**Mixed Use Development at 23-37 Lindfield Ave
and 11 Havilah Lane, Lindfield**

**MP 08_0244 MOD 1 – Modifications to
Development and Conditions**

Director-General's
Environmental Assessment Report
Section 75W of the *Environmental Planning and
Assessment Act 1979*

October 2013

1 SECTION 1
3000 SCALE 1 : 200

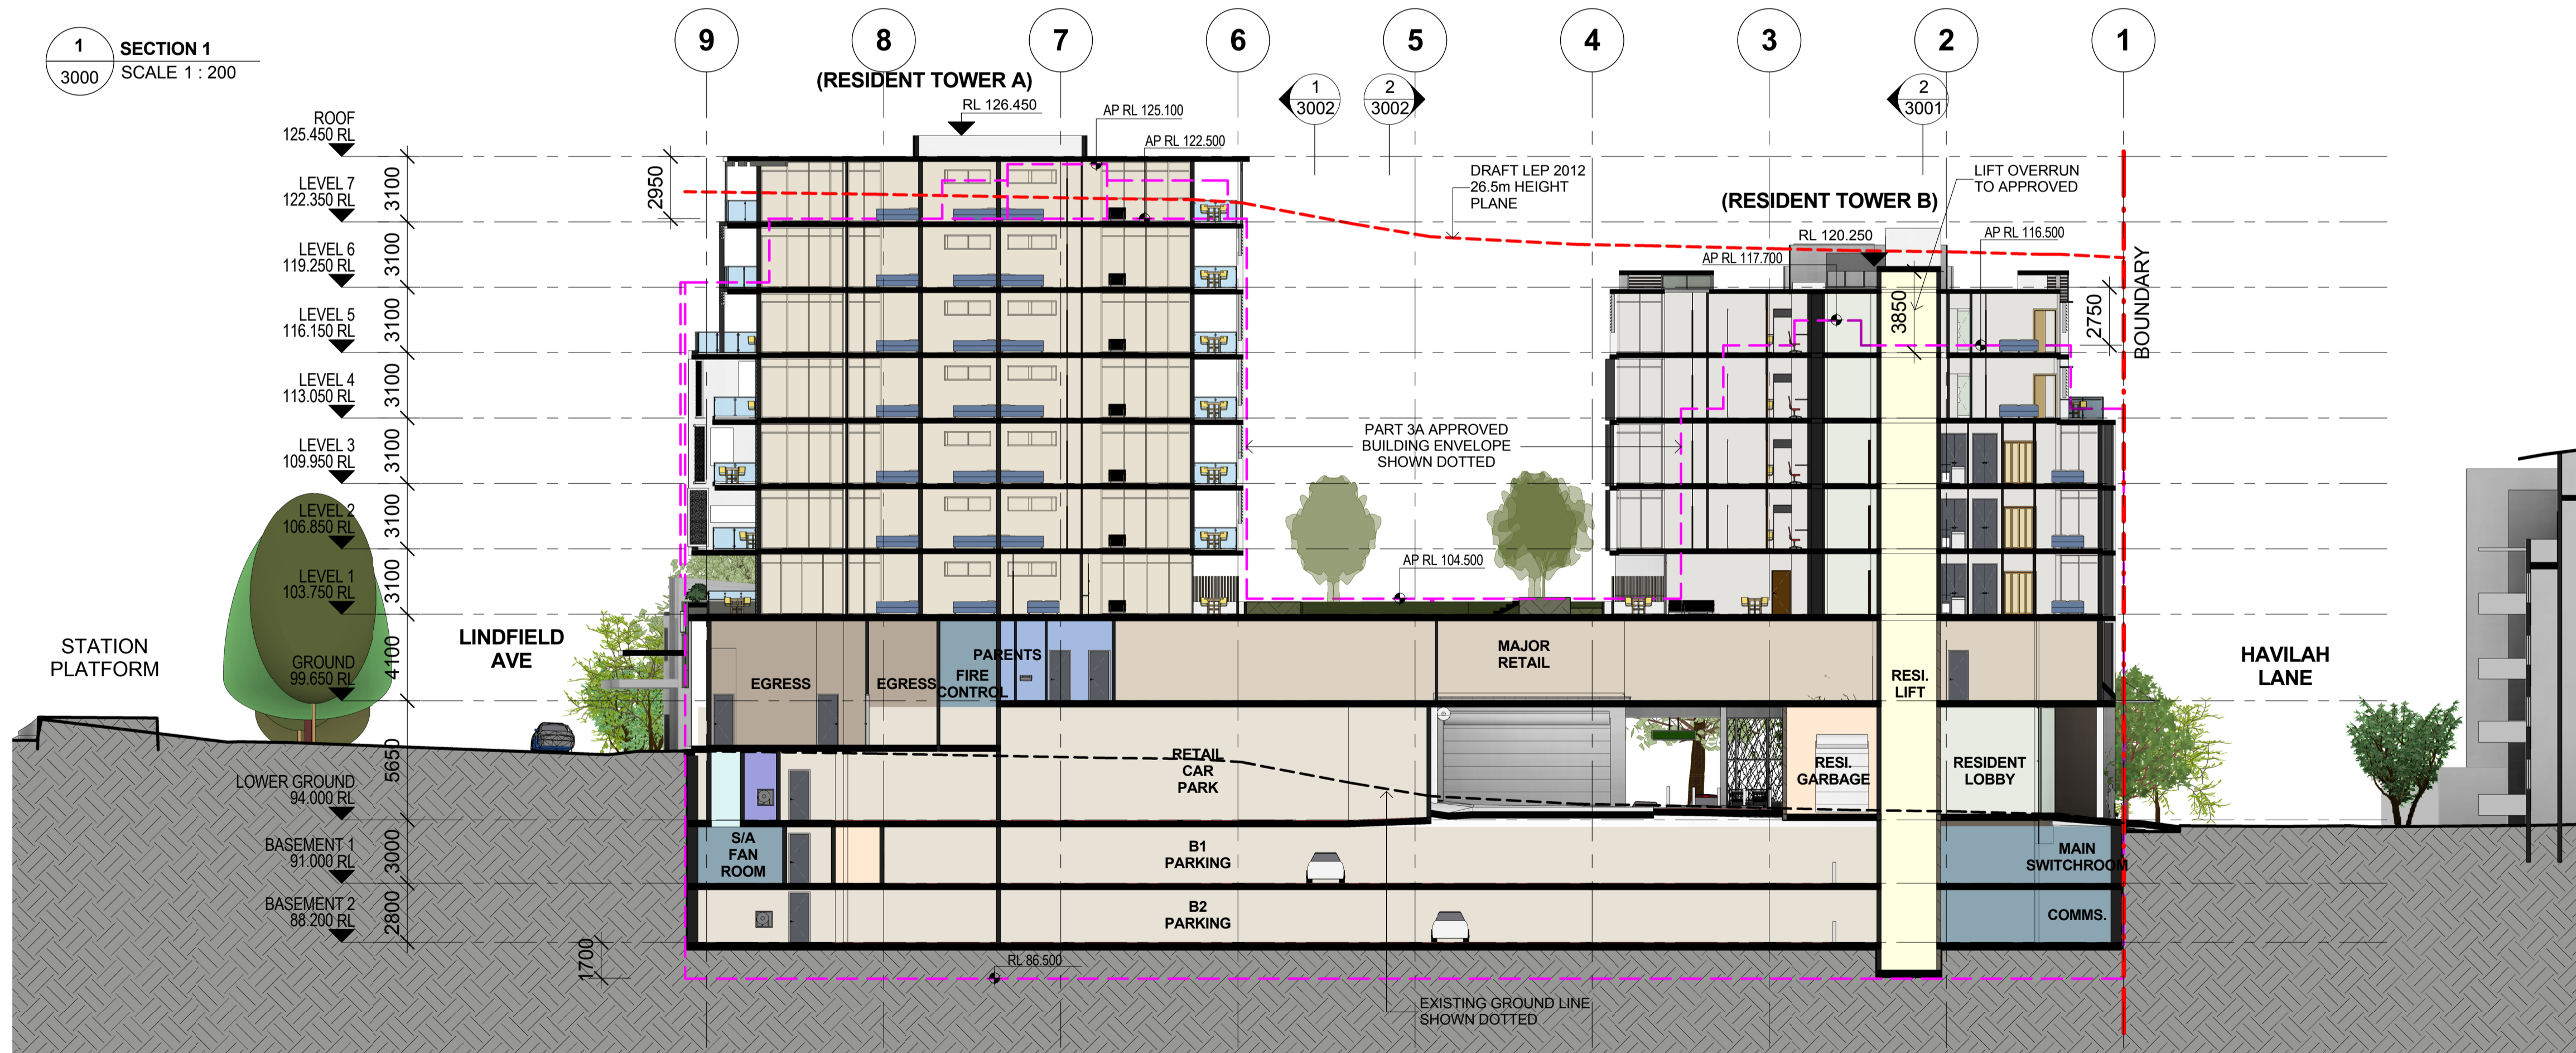
Council is of the view that the increase in height cannot be substantiated and has expressed concern that the additional height allows one extra level of residential apartments. At the same time there is a compounding loss of public benefit, namely the reduction in the quantum of commercial / retail floor space.

Council recommends that the overall building height be reduced to a maximum of 26.5 metres to be consistent with Ku-ring-gai LEP (Local Centres) 2012 and the Project Approval.

Having regard to the above, the Department considers that the proposed height is reasonable having regard to the existing and emerging town centre built form context.
